Marge Schmuckal - permit application 2013-00982 - shed

From: Marge Schmuckal
To: marioknox@gmail.com
Date: 5/16/2013 4:50 PM
Subject: permit application 2013-00982 - shed
CC: Deb Andrews; Robert Wiener

Need Historic Fees
70 Thomas St
62-B-12

062.B0.12

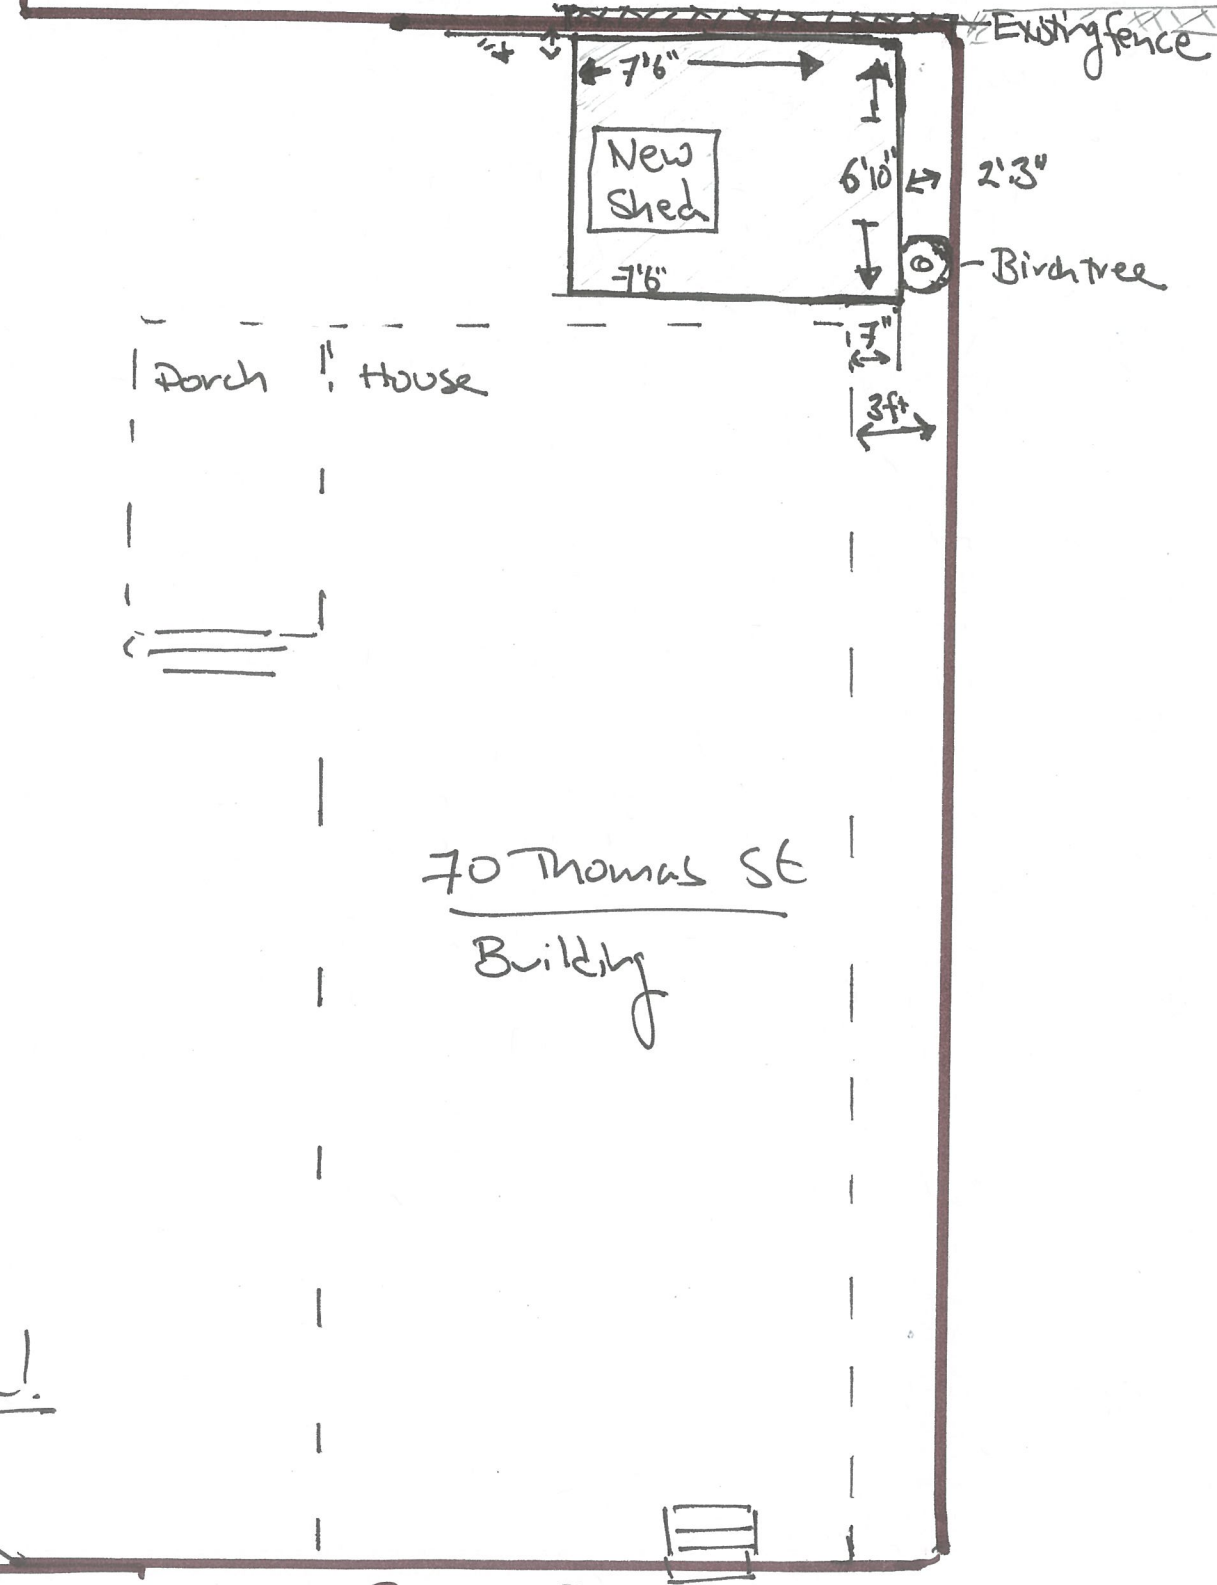
I am in receipt of your application to permit a 7'6" x 6'10" shed that has already been erected on your property. Your property is located in an R-6 residential zone which requires a minimum five (5) foot setback on the side and rear of your property [sections 14-139(a)4.b & c]. Your submission shows 4" and 3' as your setbacks. Your permit can not be approved as presently located. Your shed must be moved to meet the required setbacks or removed from the property. If you choose to move your shed, you must submit a new plot plan showing setbacks from the shed to your property lines. At that time I will re-review your application. Your new submission must be received no later than thirty (30) days from this date of notification (5/16/2013).
